Change of use from shop (A1 Shops) to micro-pub (A4 Drinking Establishment).
42 Barnham Road Eastergate

Thank you for your internet representation made on 10th August 2018 which has been recorded as '**an objection**' with the comments as follows:

PROPOSED GROUND FLOOR PLAN 1:100

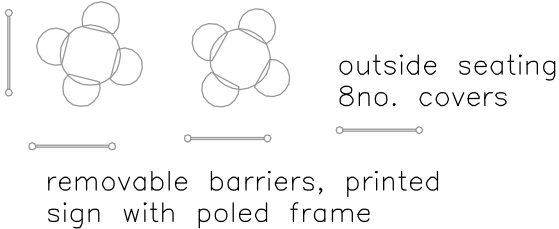
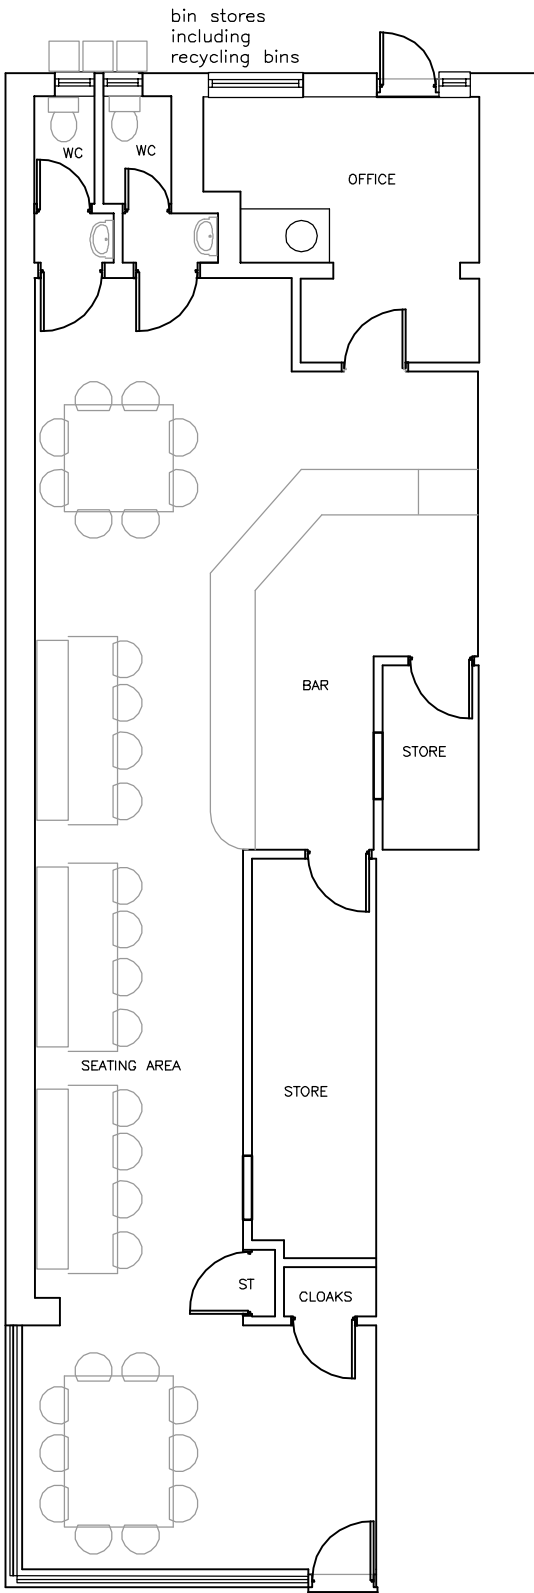
The proposed seating area for 8 people will cause a hazardous obstruction and a potential risk by protruding on to the pavement and will therefore significantly narrow the public pathway/walkway and almost blocking access to the dropped kerbs which are situated on the corner on both sides of the road at the entrance of Saxby close. The dropped kerbs are there to serve an important purpose and are extremely crucial to people with mobility/disability issues such as the blind, parents with children and pushchairs, mobility scooters and the elderly.

A clear route/walkway should be maintained at all times for passing pedestrians without causing hindrance or obstruction, The layout of the seating area should not protrude on to the public walkway so much so that it narrows or develops a hazardous obstruction/restriction, therefore, forcing the passing pedestrians dangerously close to an already busy fast moving road.
